**KIRKLEES METROPOLITAN COUNCIL
INVESTMENT & REGENERATION SERVICE**

DELEGATED DECISION TO DETERMINE PLANNING APPLICATIONS

Reference No:	2024/62/93151/W
Site Address:	167, Bradley Road, Bradley, Huddersfield, HD2 1QF
Description:	Erection of garage with raised patio (retrospective)
Recommending Officer:	Joanna Rednall

REV	DESCRIPTION	DATE	DRAWN
1	Client	Mr Faisal Hussain	
2	Address	167 Bradley Road Huddersfield, HD2 1QF	
3	Project	Raised patio and Garage	
4	Drawing	Existing and Prop Layout and Elevations	
5	Drawn	UH	DATE Oct 24
6	DWG No.	2444/01B	SCALE 1.50@A1
7	Status	Existing and Proposed

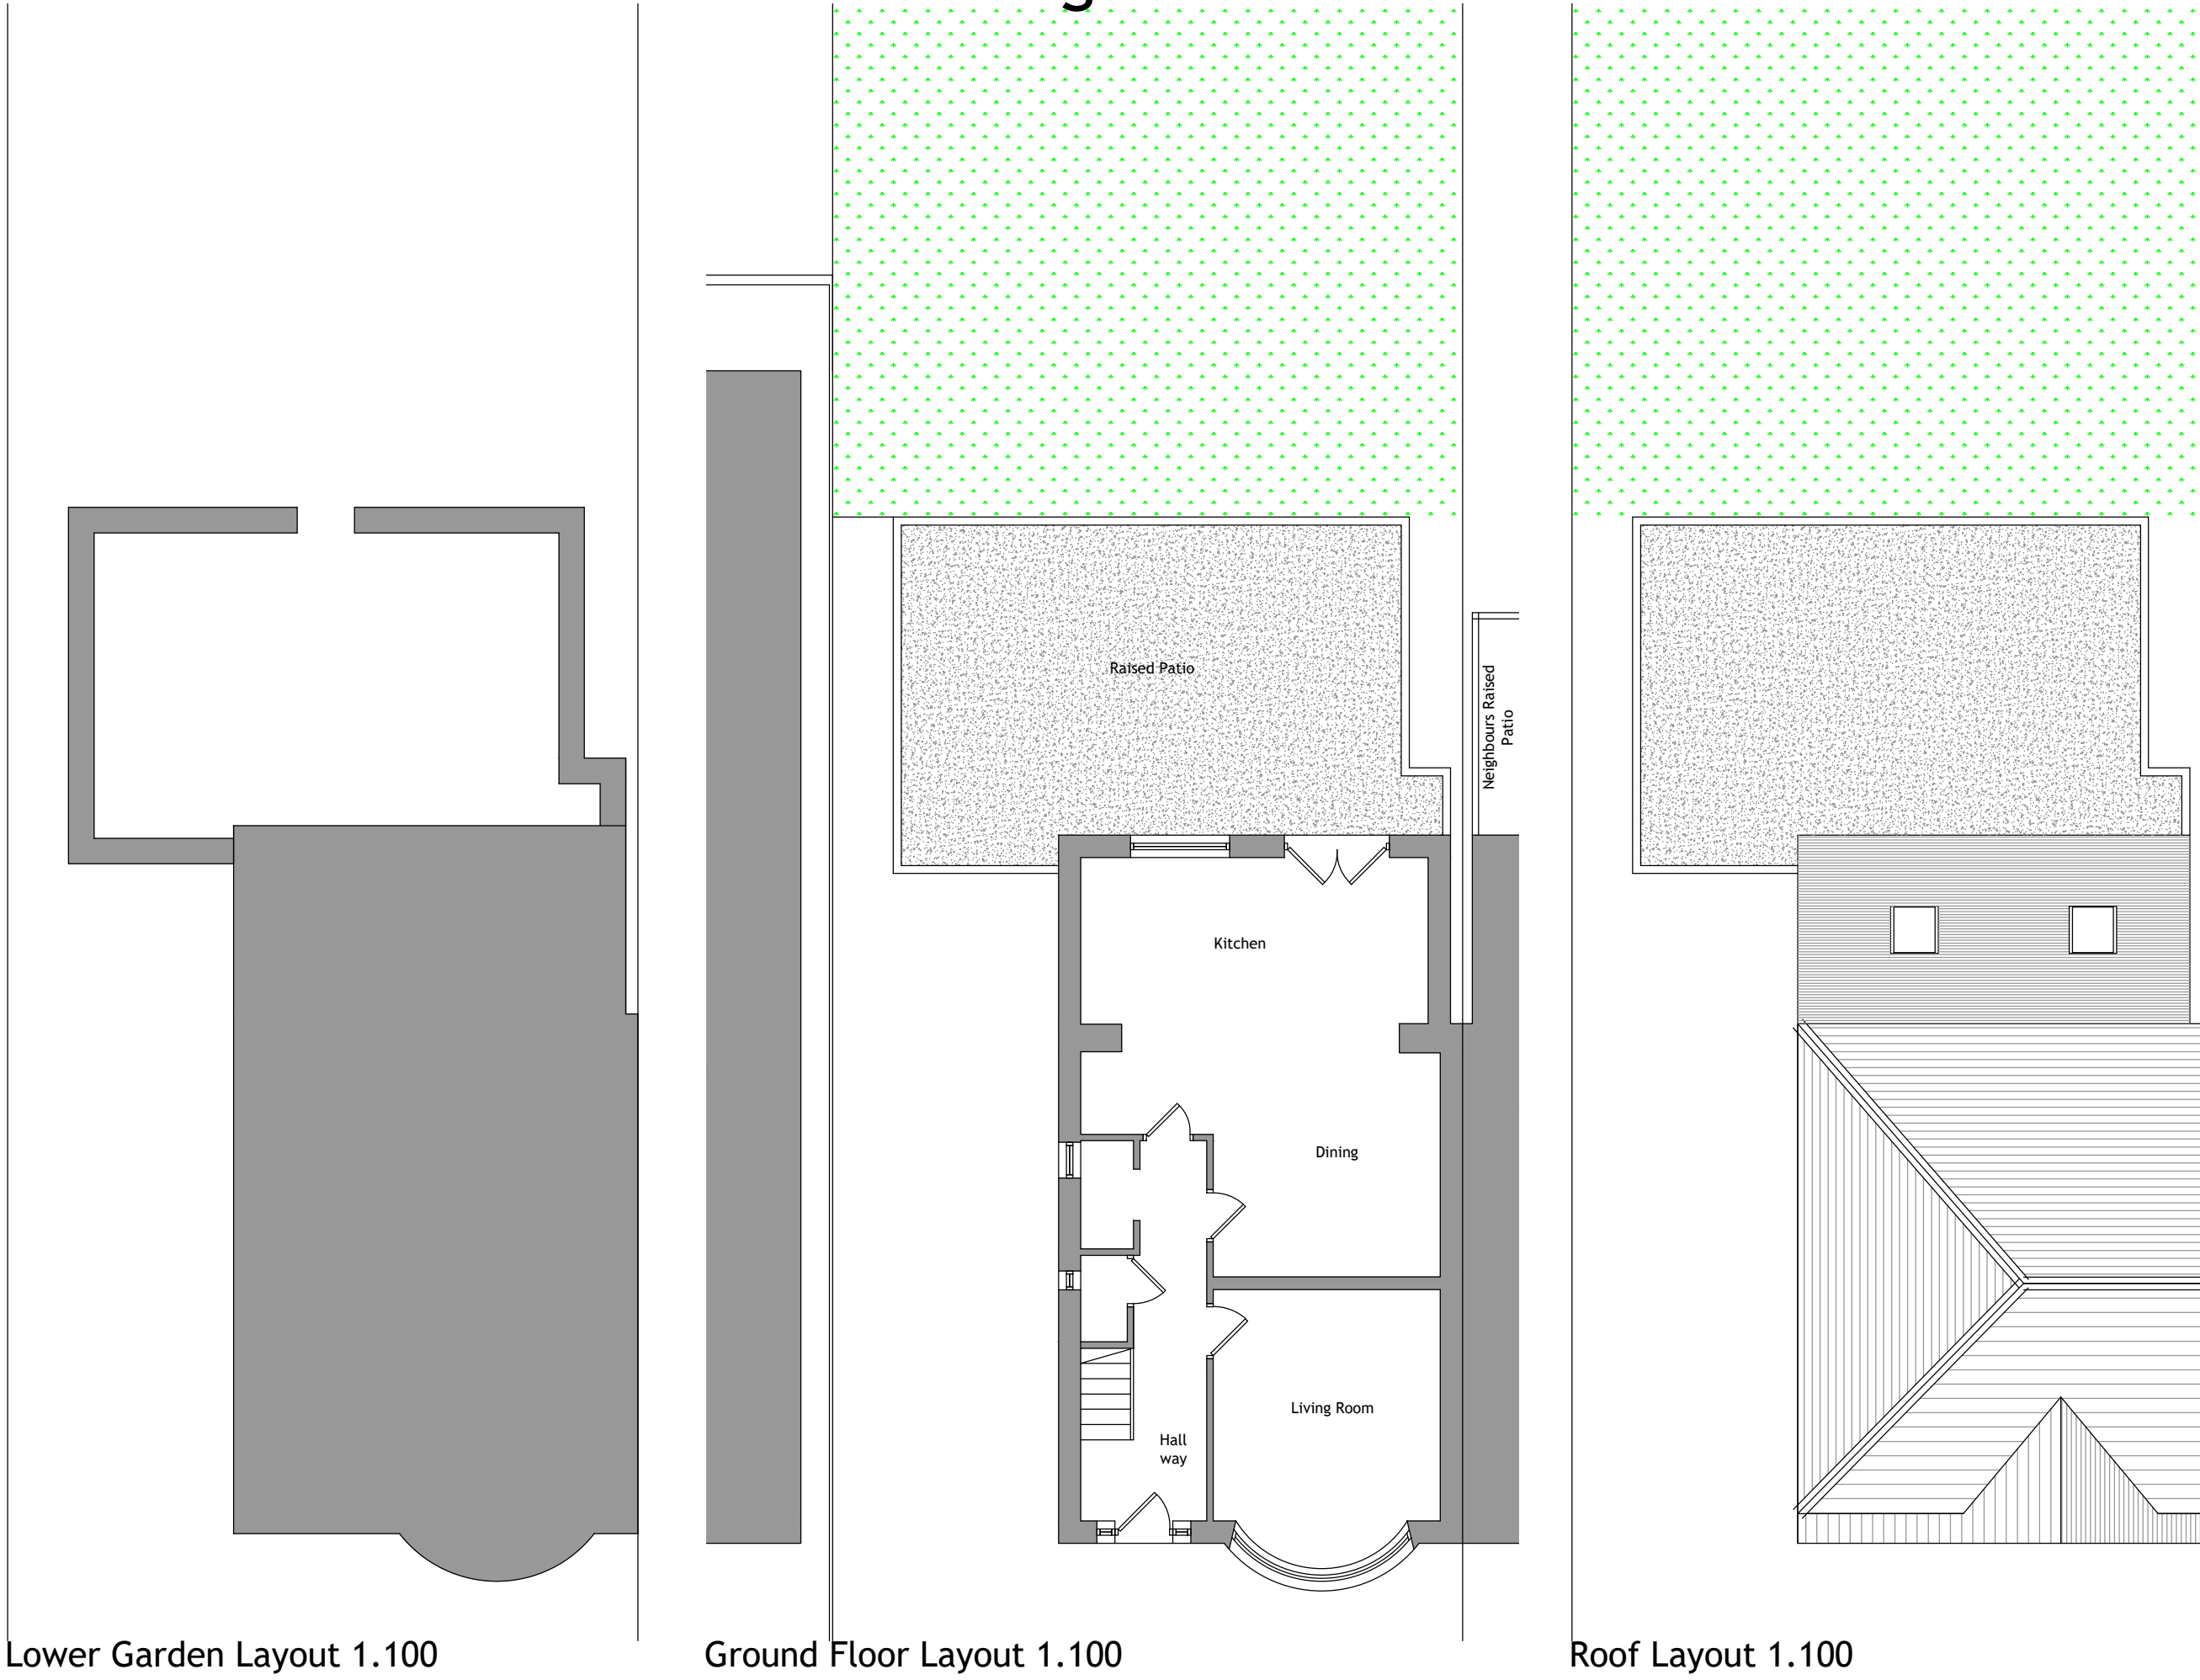
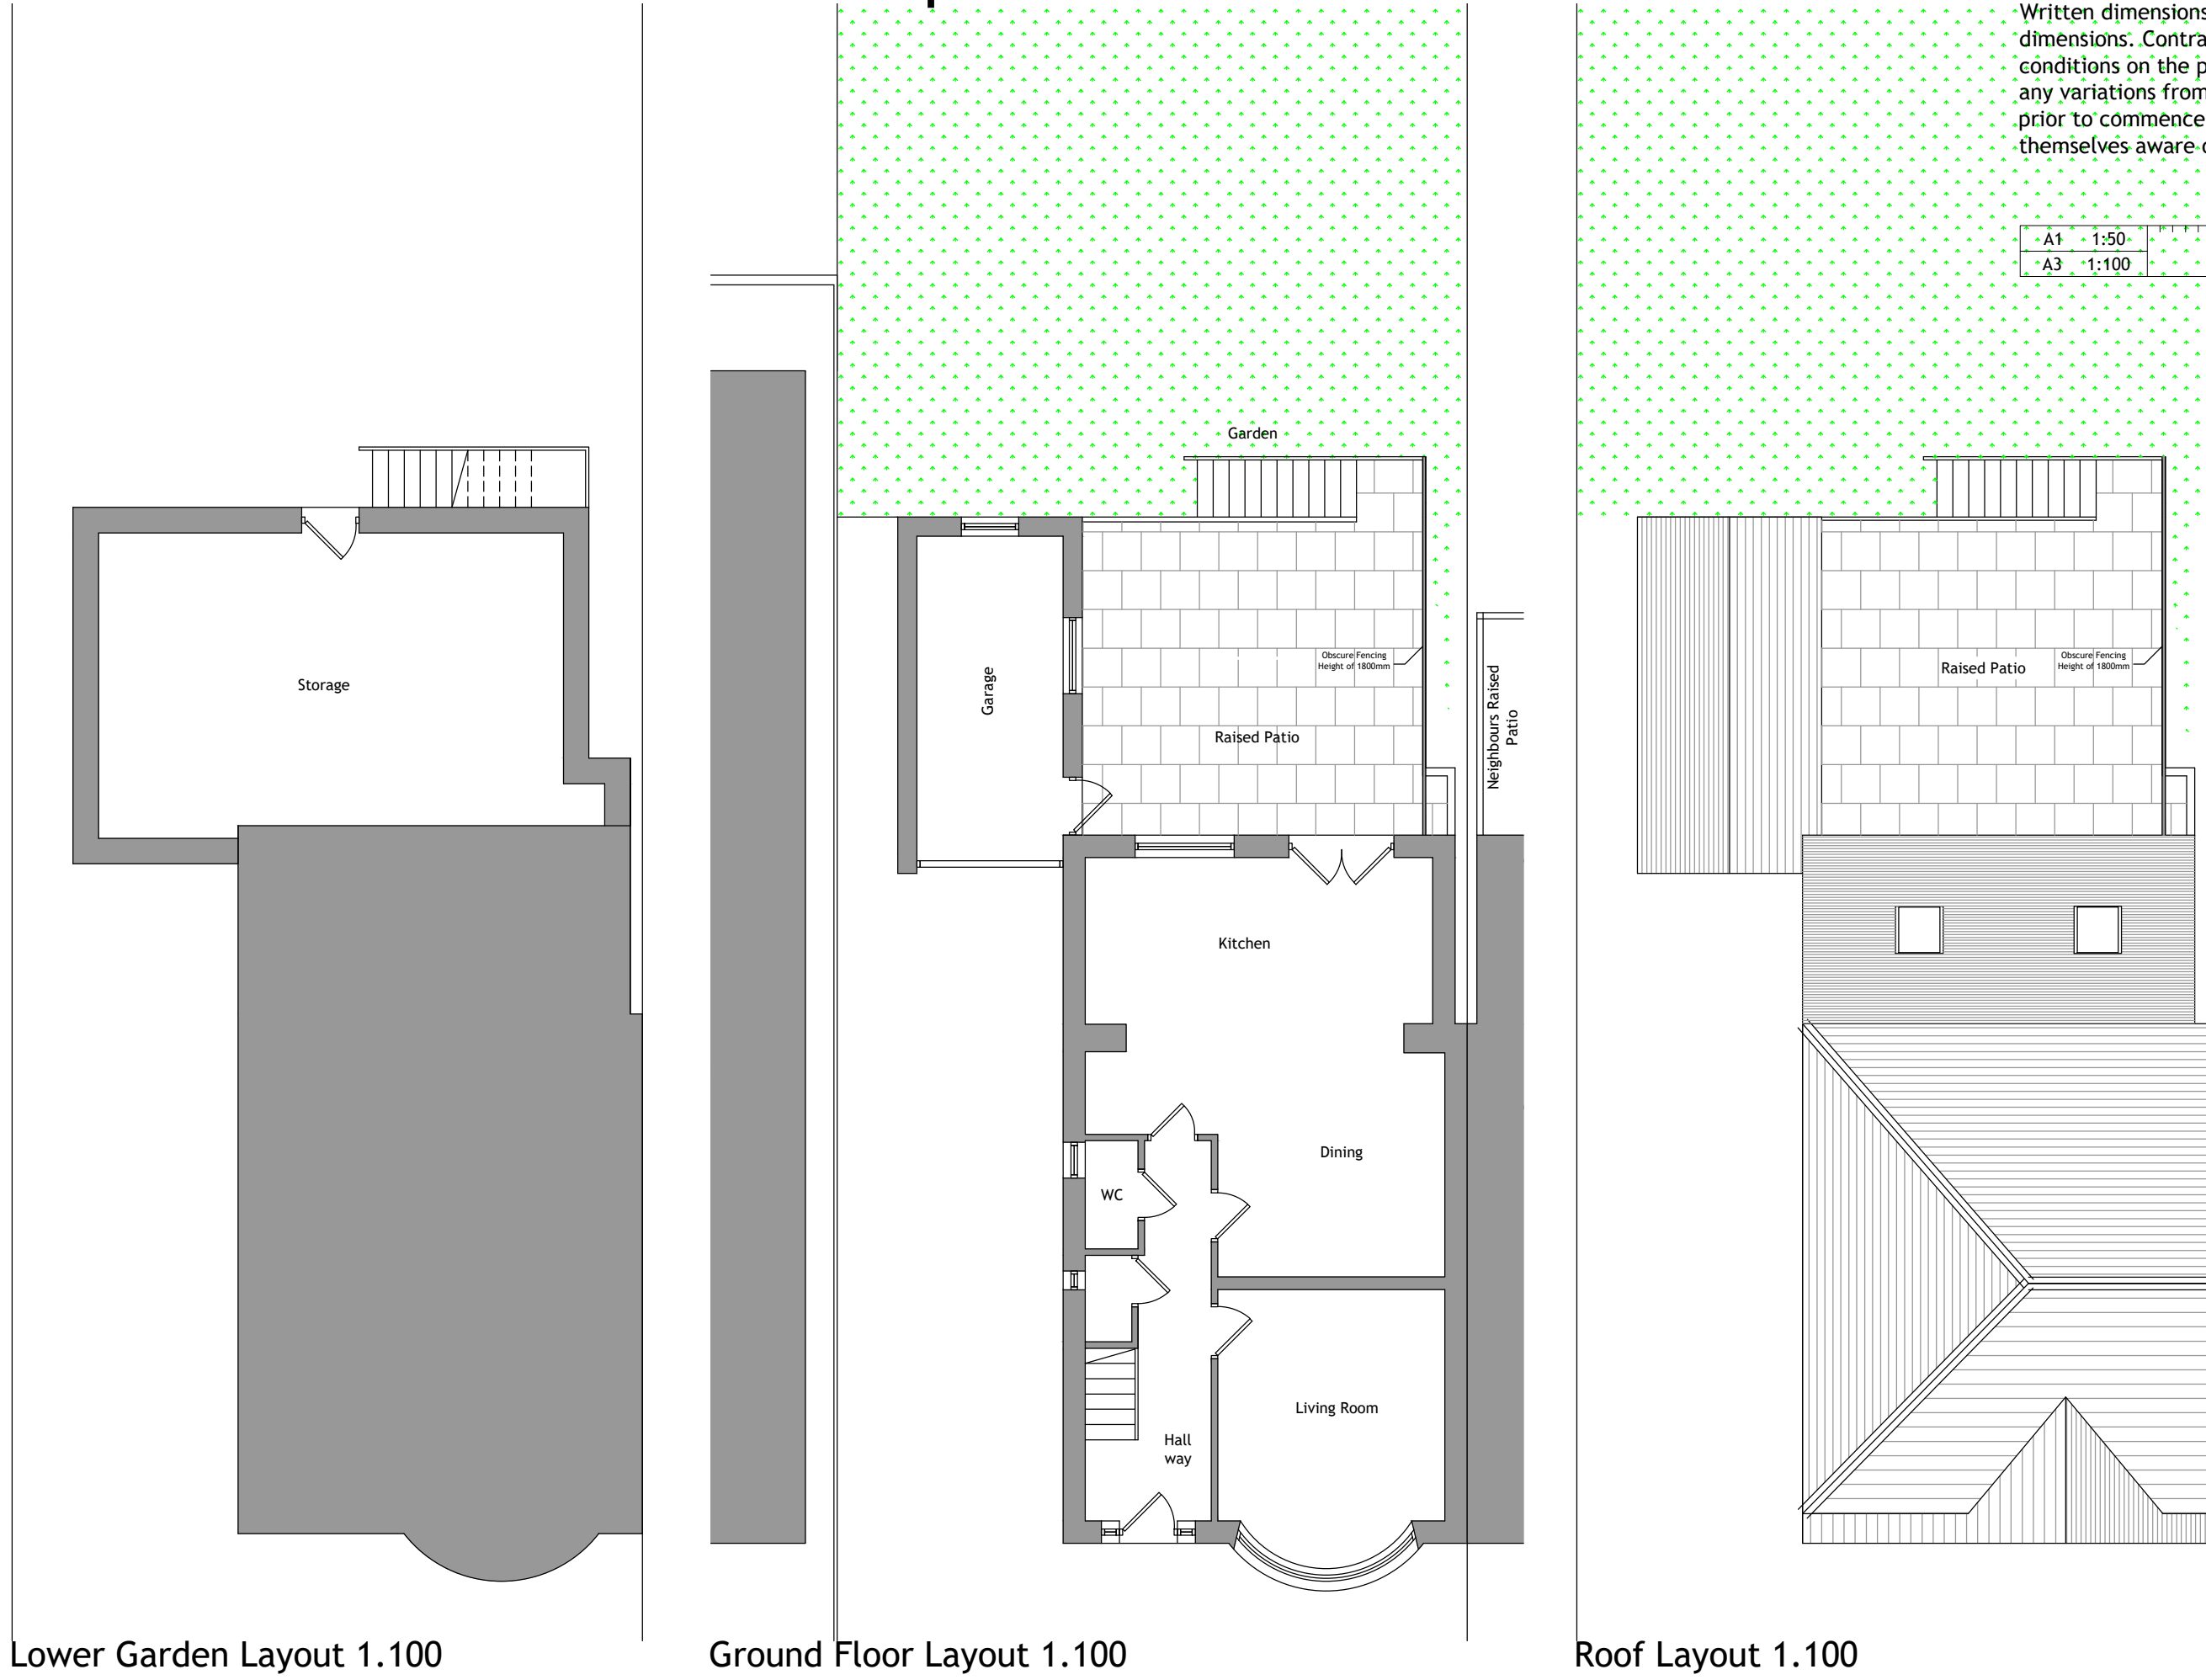
Minor amendments were made to the proposed raised patio elevations, this is in the form of a 1.8-metre-high obscure glazed balustrade to protect the amenity of occupants at No.169. The application has been determined on the basis of these plans.

Amended plans have been received showing a 1.8-metre-high obscure glazed balustrade to the west facing elevation to protect the amenity of occupants at No.169. To protect the amenity of No.169, it is recommended that should permission be granted, a condition is attached to the decision notice that the obscurely glazed balustrade to a grade 4 of obscure glazing is installed before the roof terrace is brought into use.

With regard to privacy, it has been assessed that the 1.8m obscure glazed privacy screen would mitigate any overlooking impacts resulting from the raised patio. A condition will be attached to the decision notice accordingly.

4. The raised patio hereby approved shall not be first brought into use until the obscurely glazed balustrade shown on the approved plan reference 2444/01B has been installed in complete accordance with the detail shown on that plan and to a grade 4 degree of obscure glazing. Thereafter, the obscurely glazed balustrade shall be retained in accordance with the details shown on the approved plan and the requirements of this condition.
